Re: **Proposed: Tourist Facility**
Property: LOT: 2 DP: 747399
4177 Nelson Bay Road ANNA BAY

With respect to the state significant development application SSD5916 (our ref. 25-2015-1-1) for an Eco-Tourist Facility – 'The Bay Resort' at the above mentioned property, Council has reviewed the proposal against relevant legislation and Council requirements. Council makes the following comments with regards to section 79C of the Environmental Planning and Assessment Act, 1979:

DRAWING TITLE	CIVIL ENGINEERING PACKAGE CIVIL DETAILS - SHEET 2
---------------	--

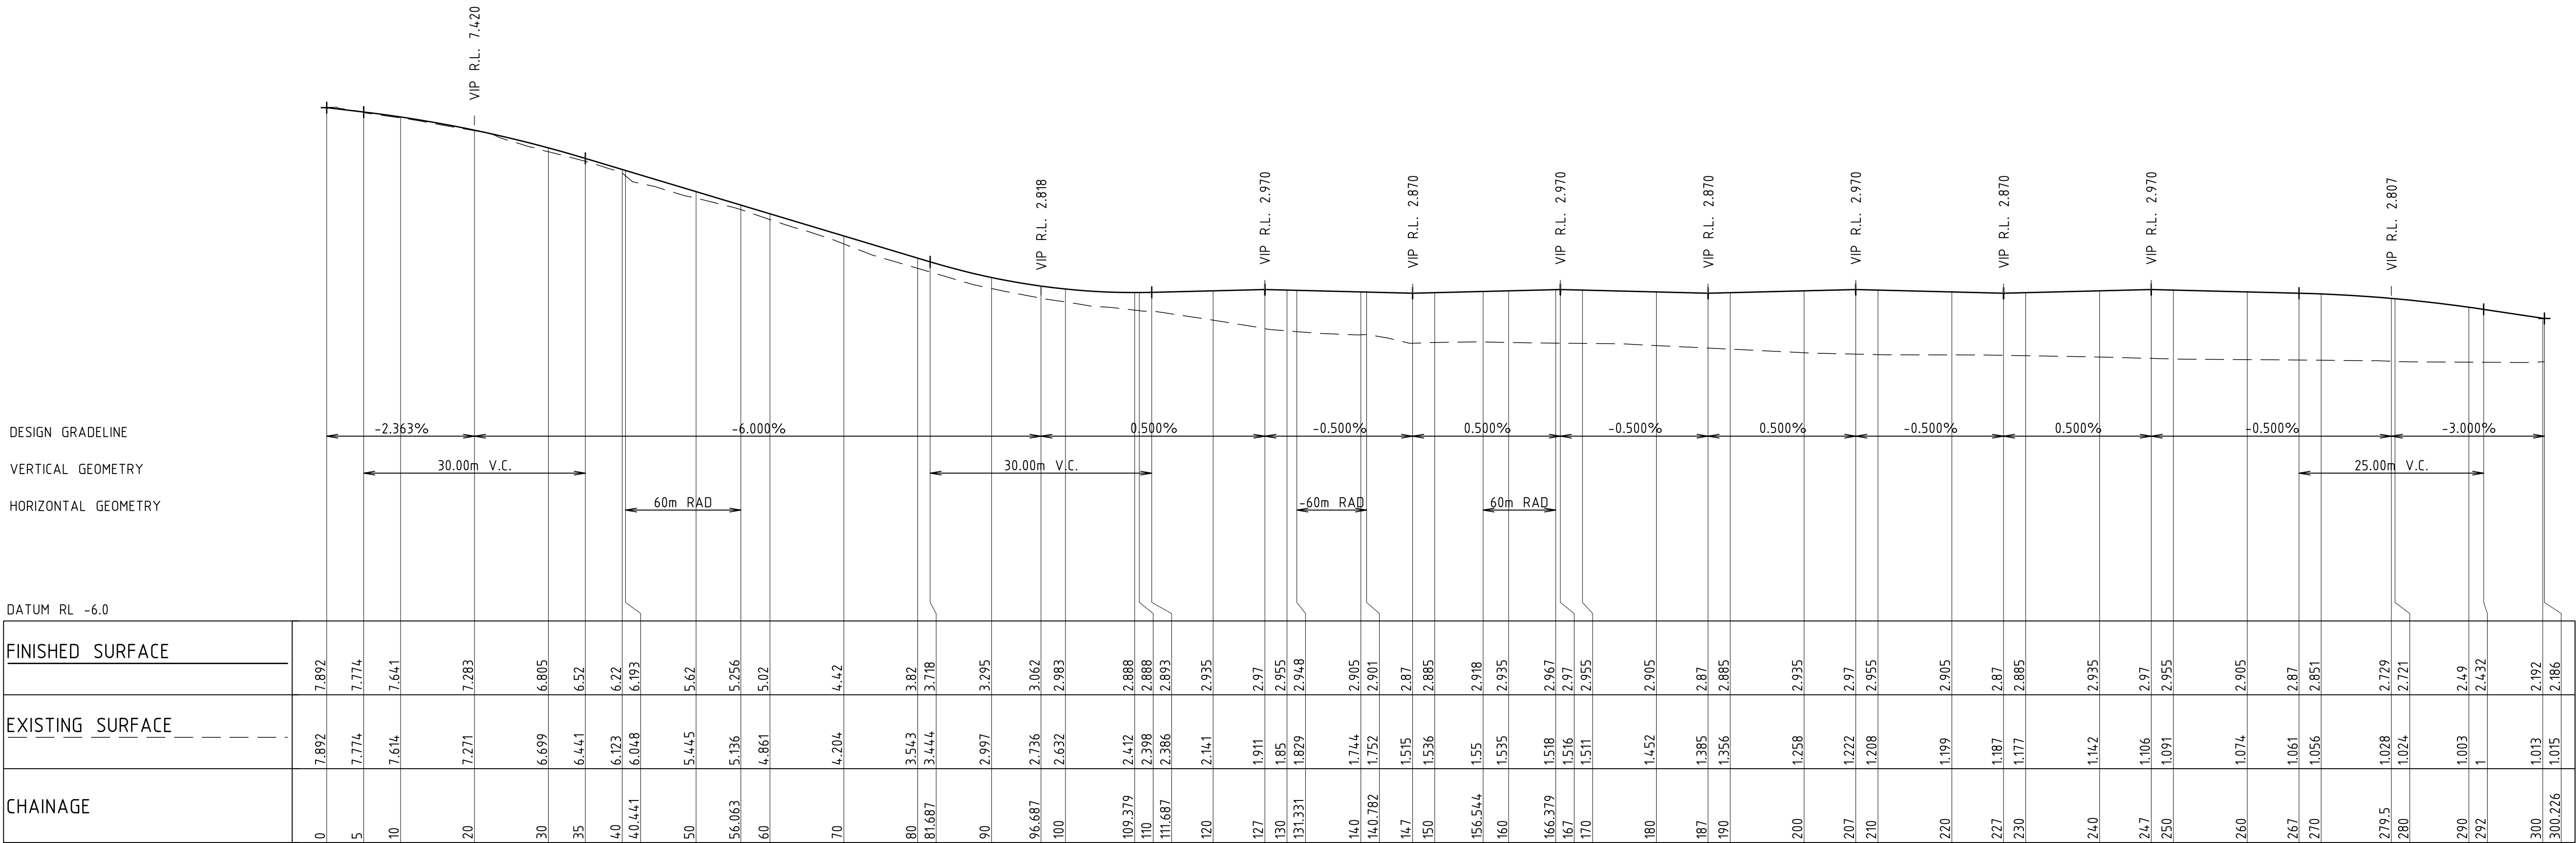
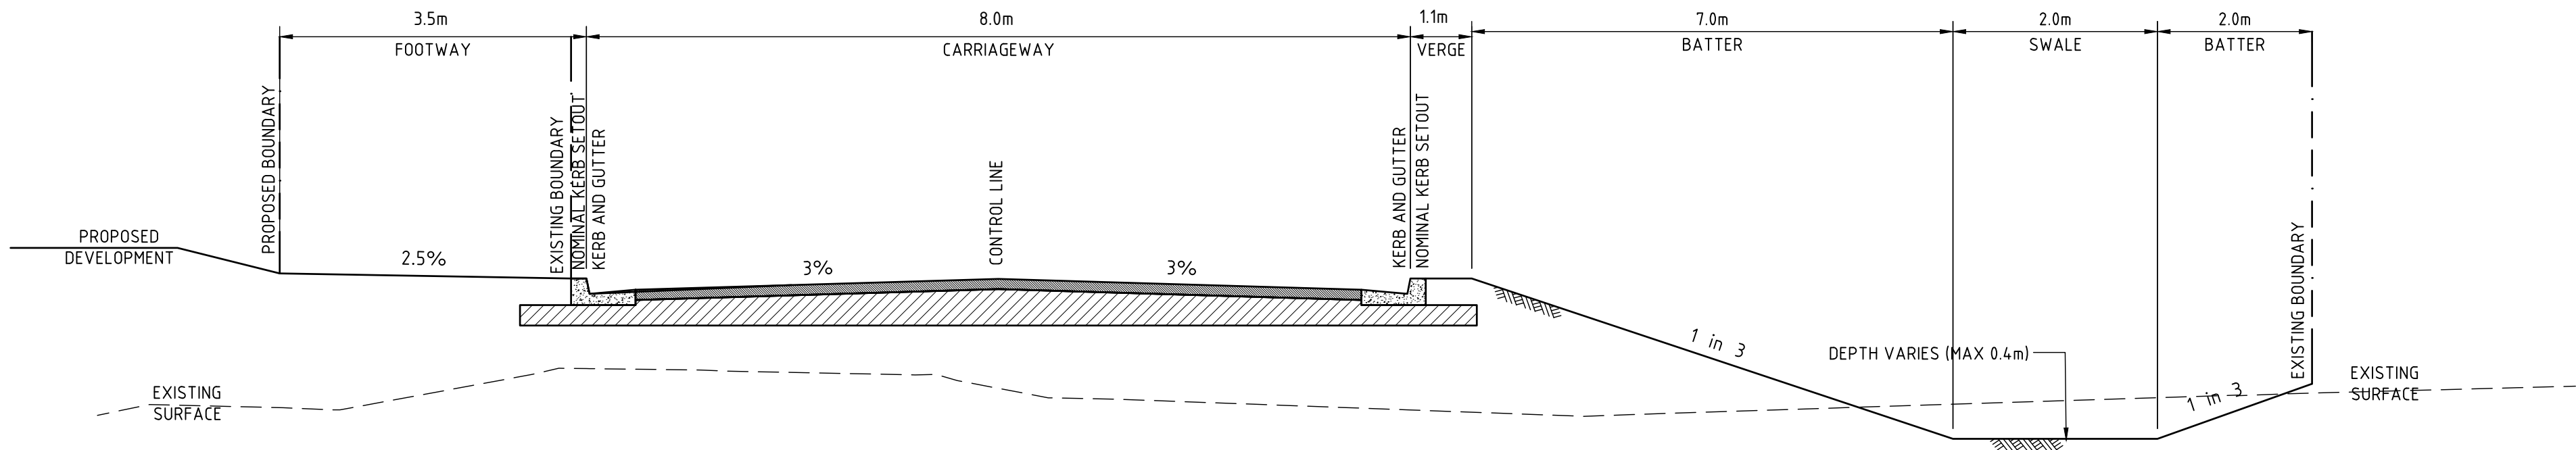
In the flood report recommendations it is noted that the raising of the Crown Road to the proposed level of RL 1.8metres AHD has the potential to become a hydraulic barrier with a resulting negative impact on adjoining upstream properties. However, for flood evacuation Council has previously recommended that the road be raise to a minimum level of RL 2.5metres AHD, to facilitate evacuation and to match the internal circulation road level. Raising the road level may have an unacceptable negative impact on adjoining properties and will also make it more difficult to provide for normal stormwater drainage within the available road reserve.

- In accordance with previous advice submitted to inform the DGR's for the development, the minimum finished surface level should not be less than RL 2.5m AHD;

- The road should be a 'local street' with a minimum 9metre carriageway and 2metre wide dual use path on the western side of the road;
- A turning head is required on the northern side of the second site access and should be offset into the development site to accommodate a 30metre diameter road reserve and turning head with a minimum turning radius of 12metres. The additional road reserve should be dedicated to Council as public road;
